Date: 22nd September 2022

Application 3/2022/0827: Application for planning permission for proposed single storey extension to the rear, removal of existing uPVC window and door to the rear of the lower ground floor. Installation of 2 conservation roof lights in rear roof pitch, with internal lightwells to ceiling. New stud walls to form en-suite on the second floor. Removal of existing external soil stack to the rear and installation of new internal soil stack. Removal of existing garage and construction of replacement garage. Resubmission of application 3/2021/0985

Application 3/2022/0828: Application for Listed Building Consent for the above works

84 Whalley Road Clitheroe BB7 1EE

Drawing Title
Proposed Plans and Elevations

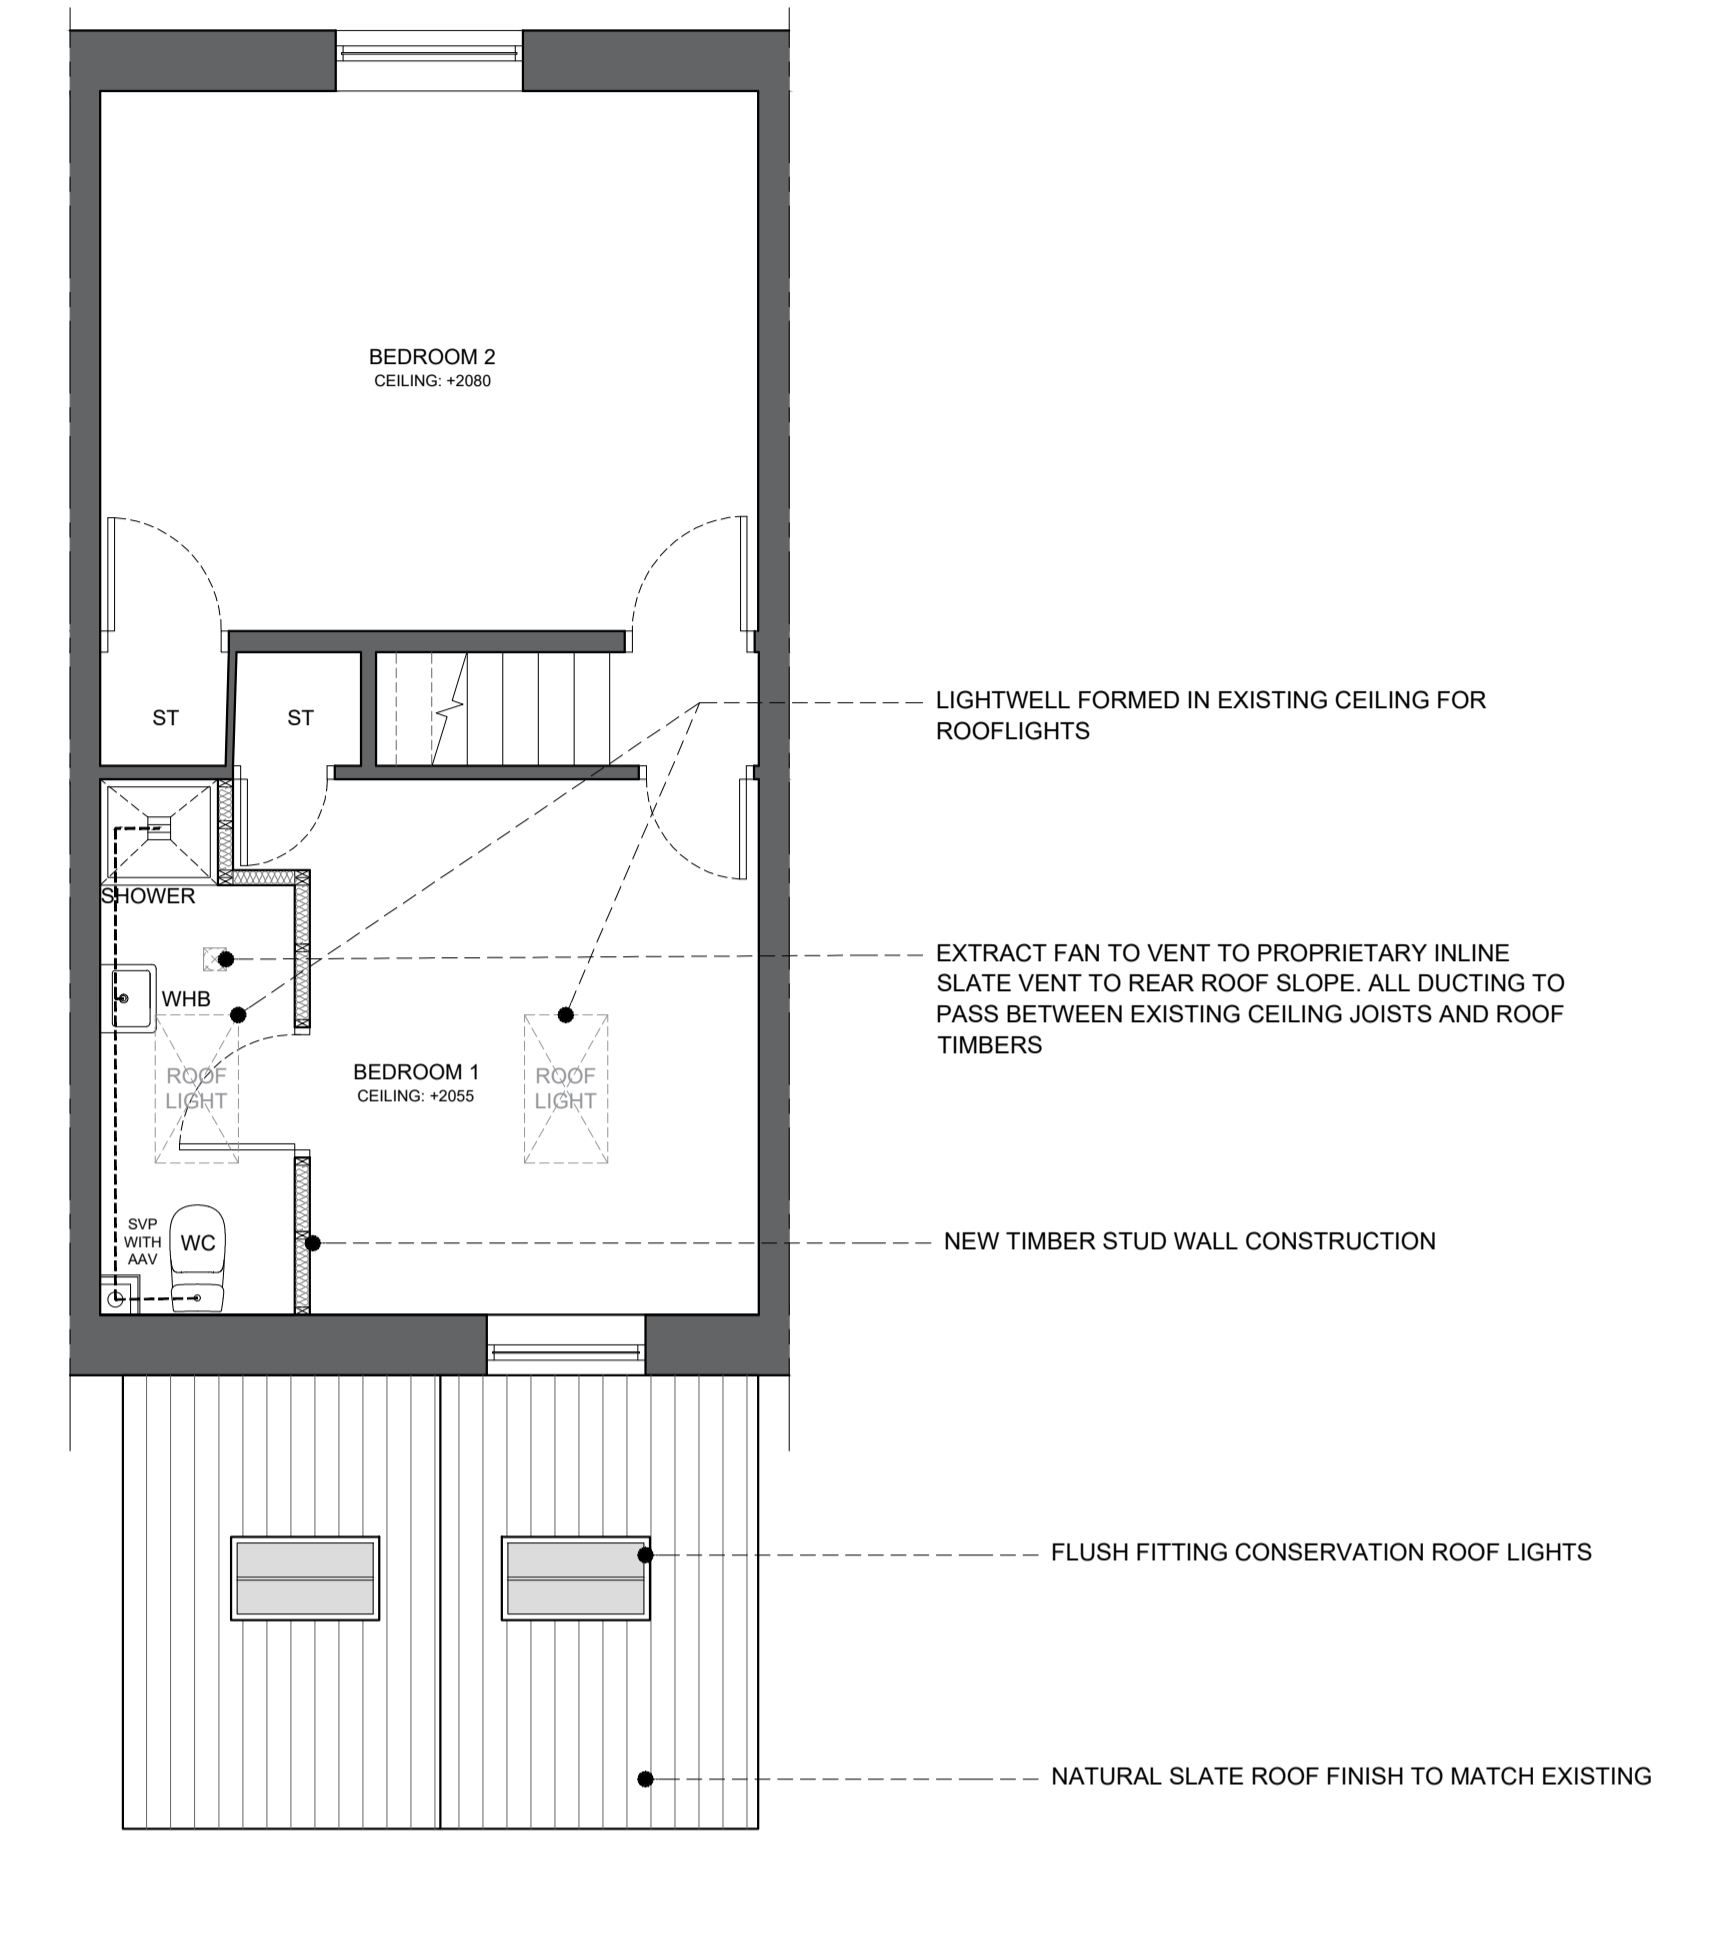
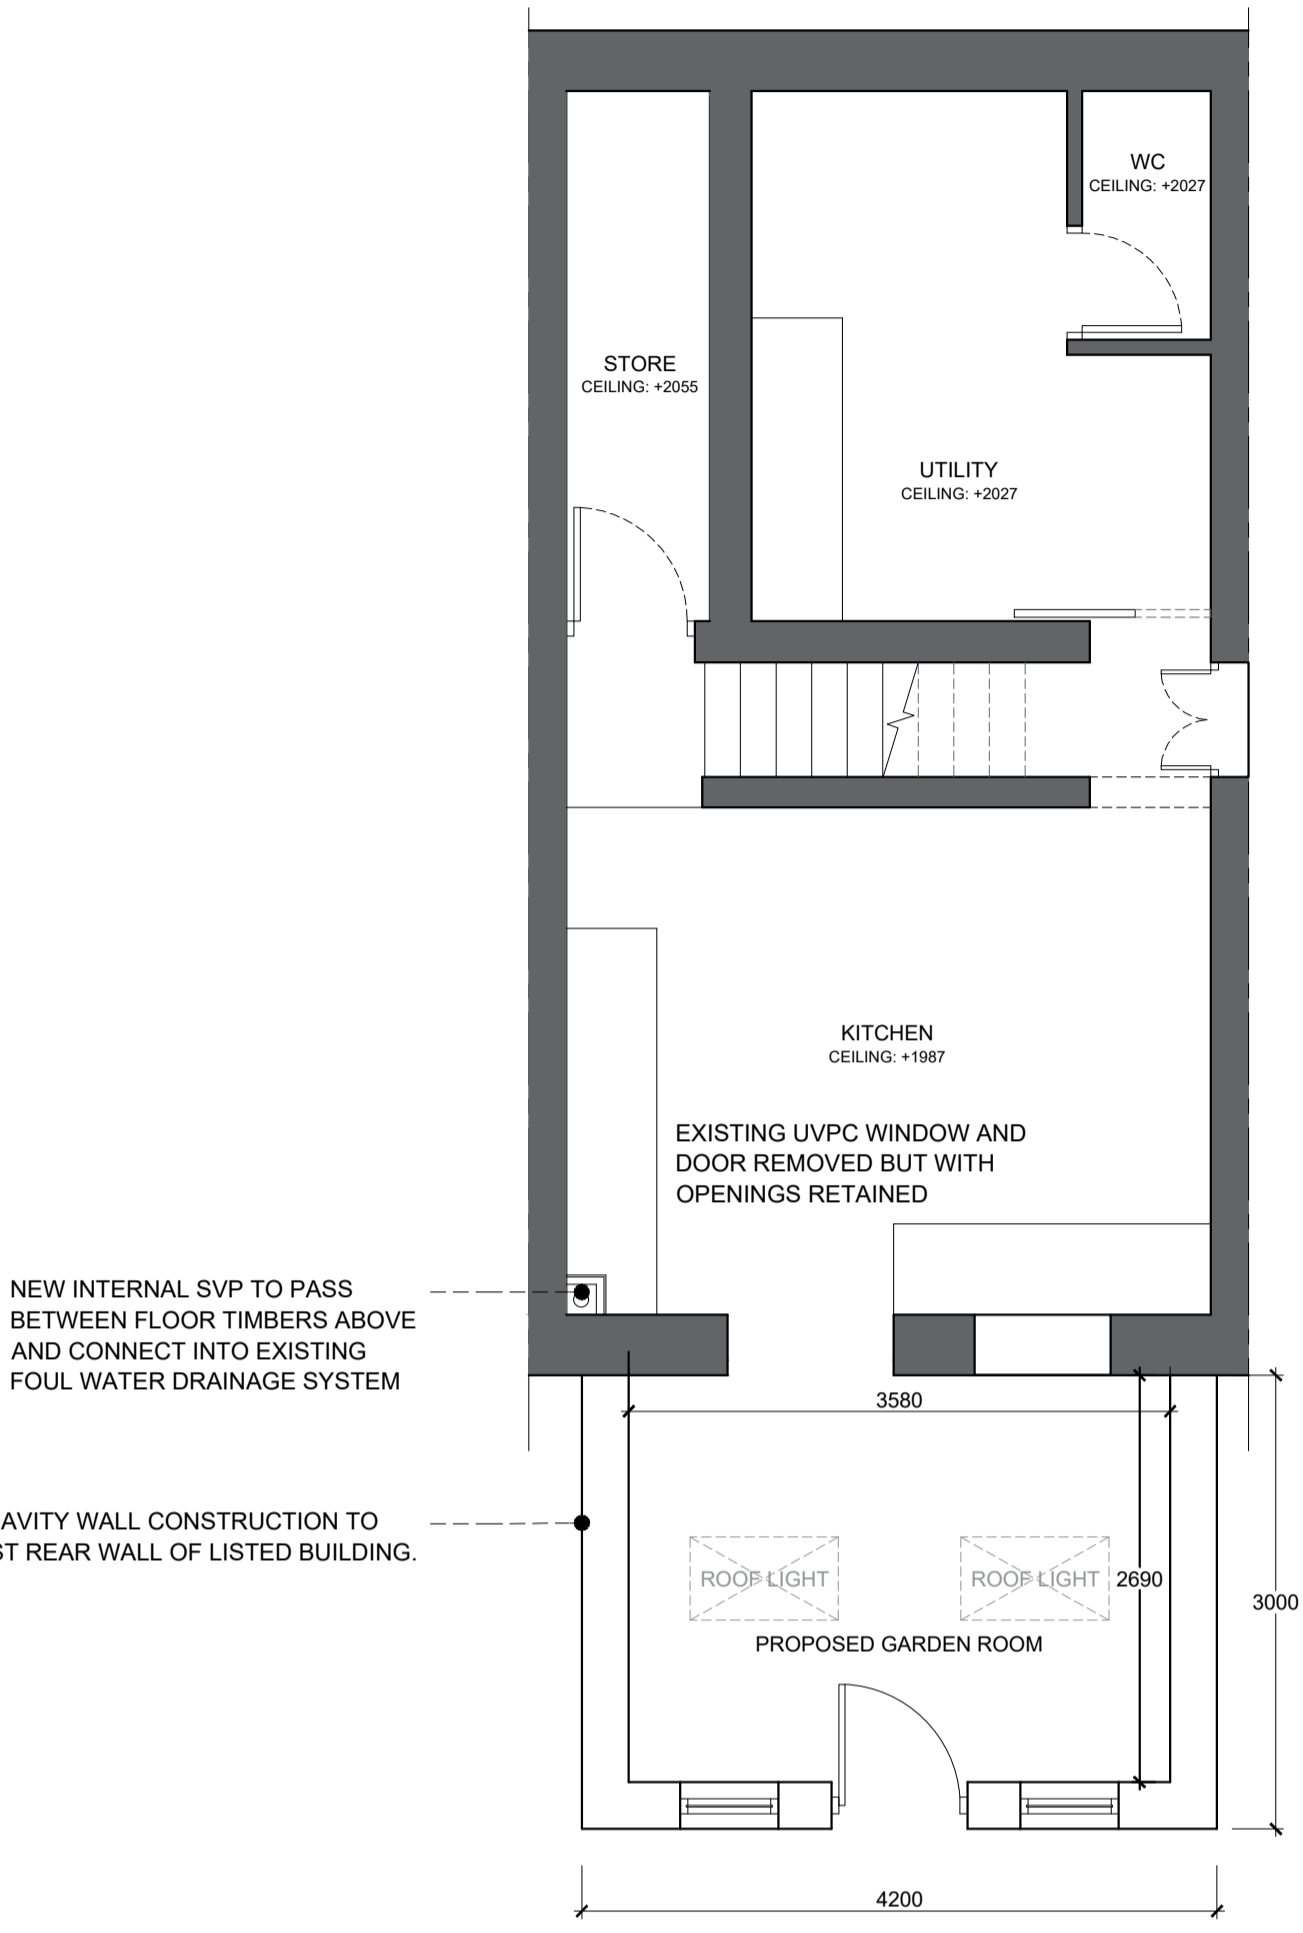
We would support the reasons for refusal of the previous application and be content to leave consideration of the impact of the revised proposals to the Borough's Conservation Officer, but would note that there are few rear extensions to this row existing and that there is public access to the rear of the property via the side/rear car park and access track, as well as the public open space of the former Primrose Mill lodge and race immediately to the northwest. Google Streetview images dated July 2016 would suggest that views of the rear of the property are rather more than 'minimal' as stated on page 7 of the Heritage Impact Assessment (SPA, Sept. 2021). Whilst fences and vegetation do conceal much of the present lower ground floor walls, the proposed extension and its modern gable-end openings may well be more visible.
